# SOUTHERN ENGINEERS

**PROJECT #:** 19-1621-A

**DATE:** April 23, 2020

**PLANS REF:** Rachford Residence by Design Tech

FOUNDATION STRUCTURAL PLAN  
SCALE: 1/4" = 1'-0"  
REFER TO "SD" SHEET(S) FOR STANDARD DETAILS AND STRUCTURAL NOTES

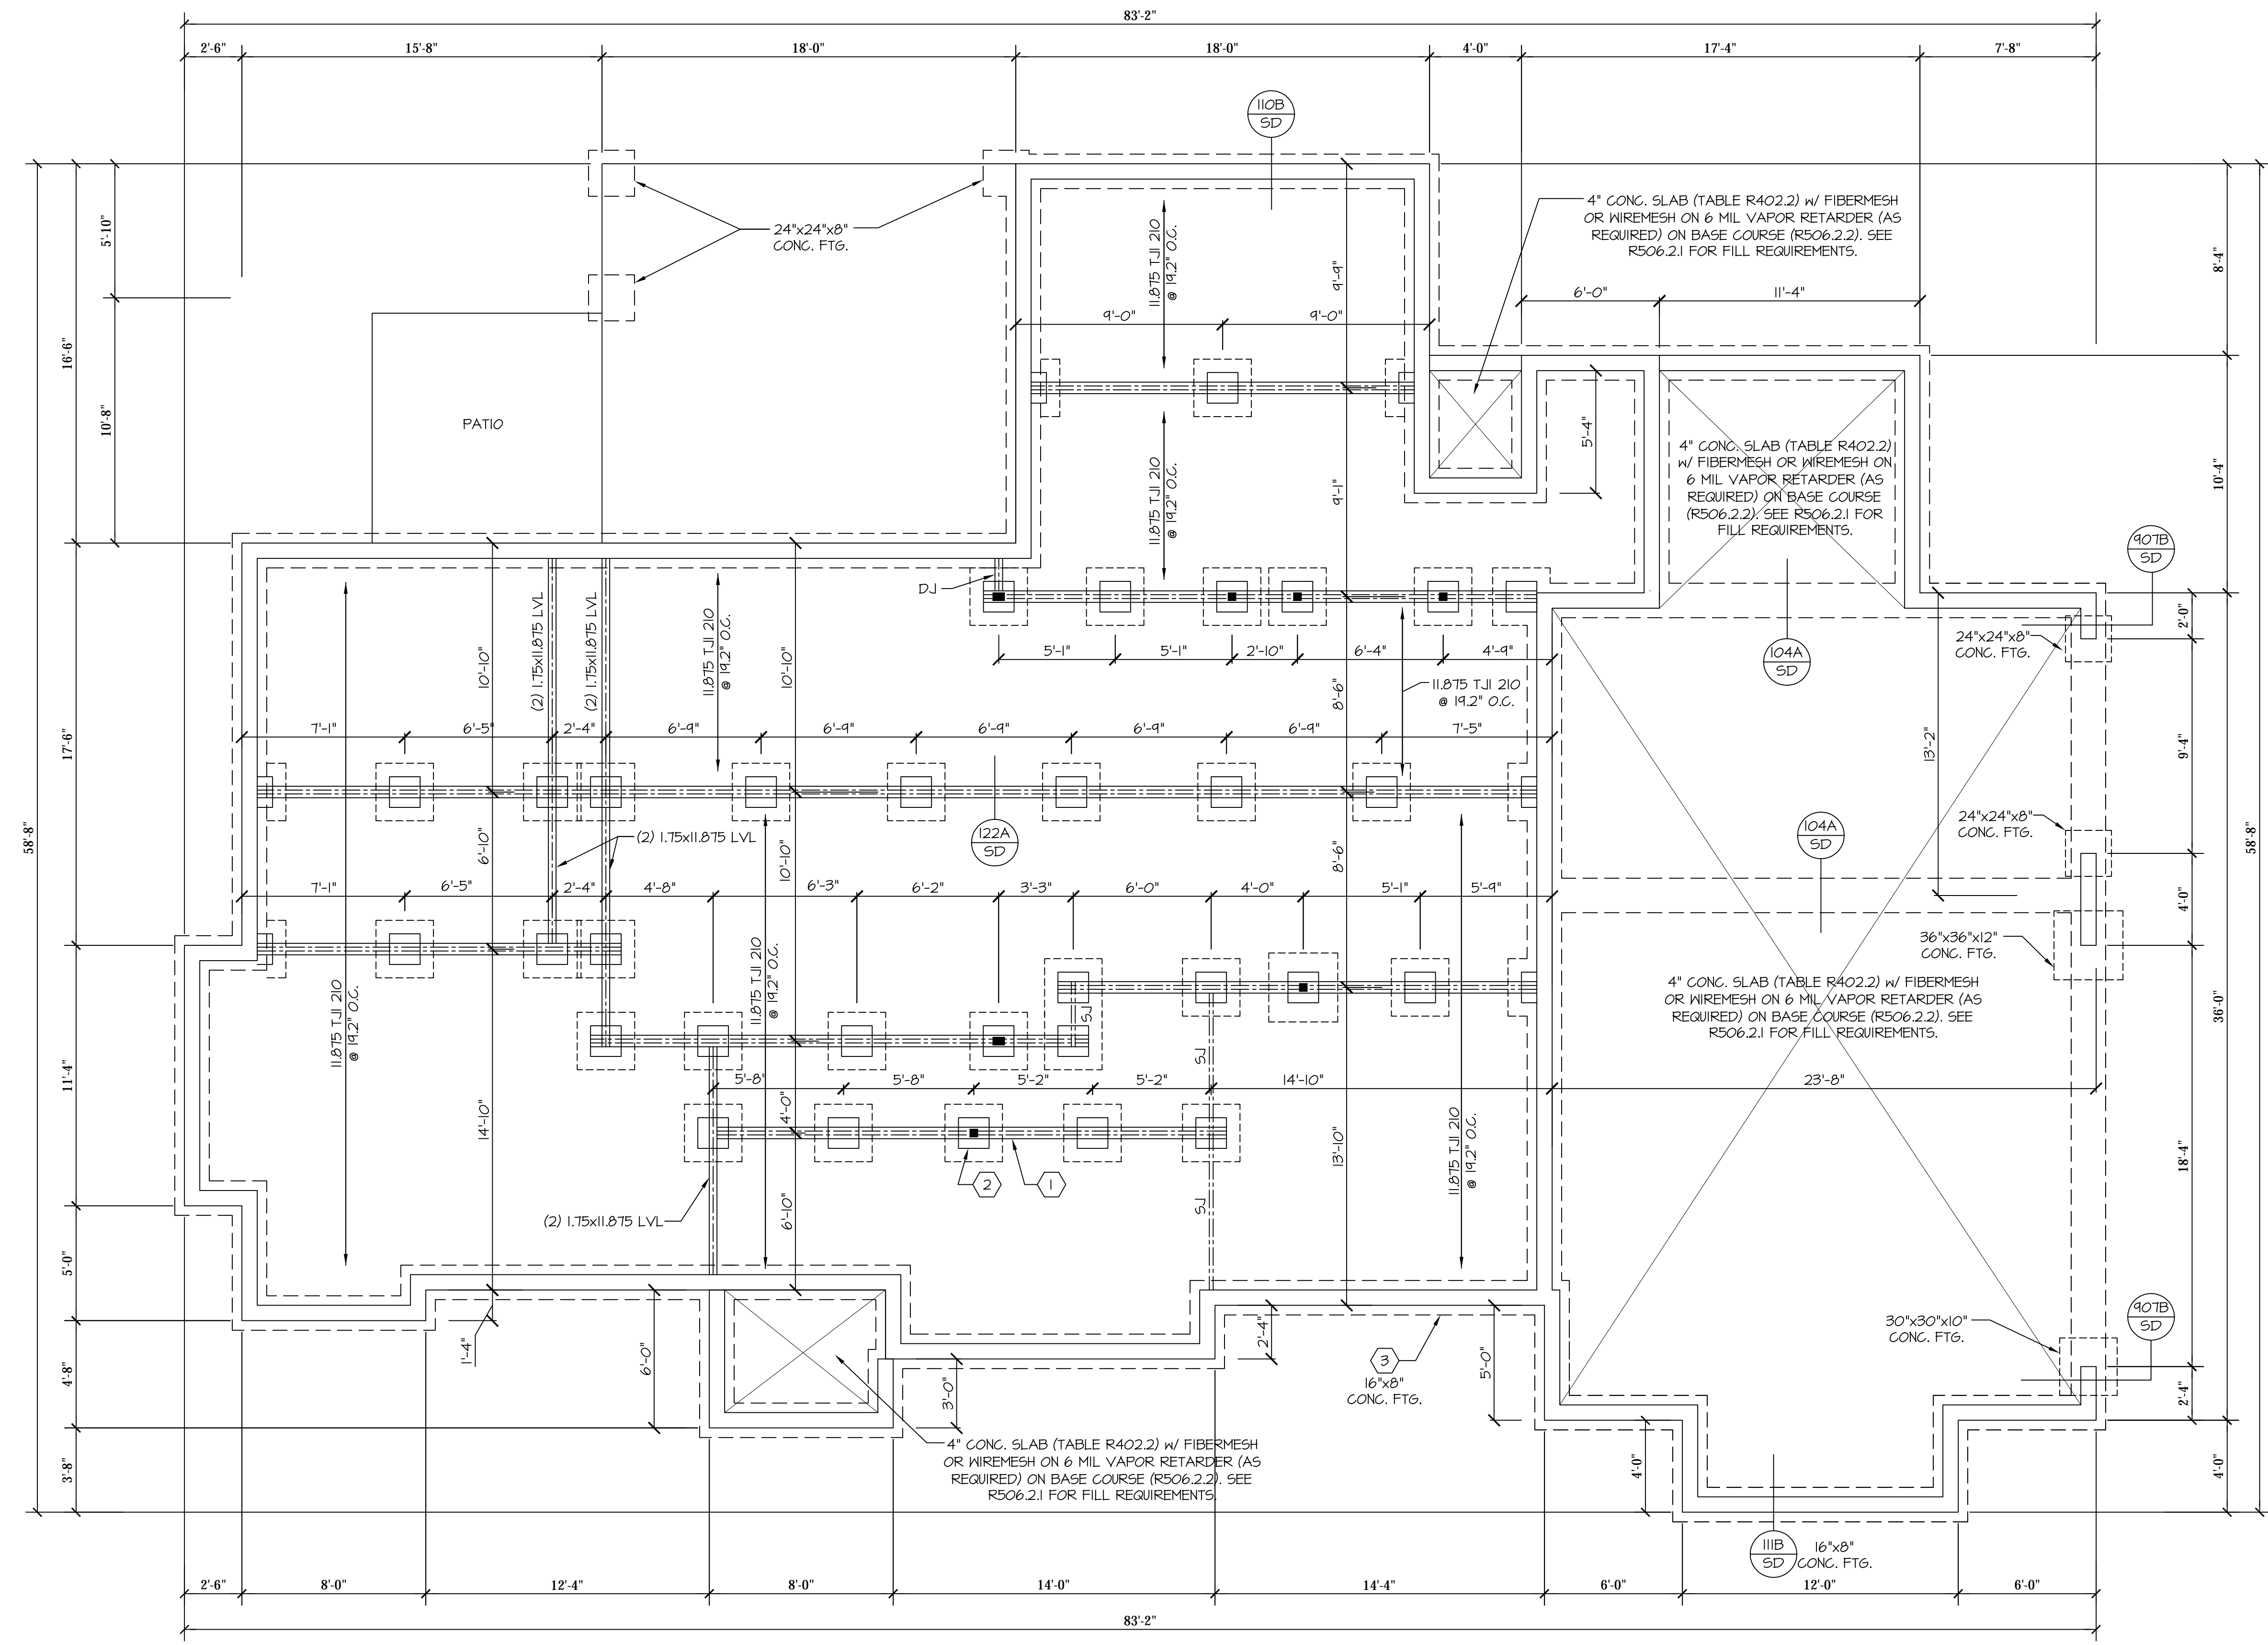
**Garage Foundation:** Plans show a continuous footing between the 9 foot and 18 foot garage door openings.

Please be advised the continuous footings are optional and therefore may be omitted.

115-120 MPH 110B SD CRAWL SPACE FOOTING (SIDING W/ BRICK SKIRT)

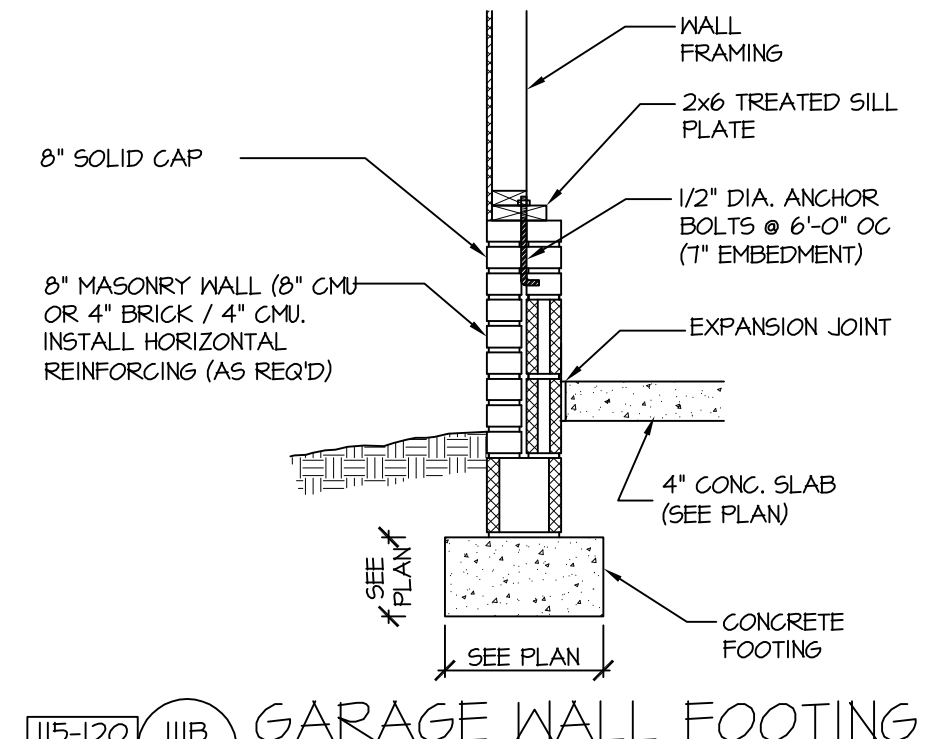
**Footing Projection:** Per information and pictures from builder there are several areas on the foundation which lack the 2” minimum footing projection requirement.

Number 4 dowels were drilled into the side of the footing at approximately 24” centers. A #4 bar was installed on top of the dowels and 8” of concrete footing will be added.

Please be advised the repairs noted are structurally adequate.
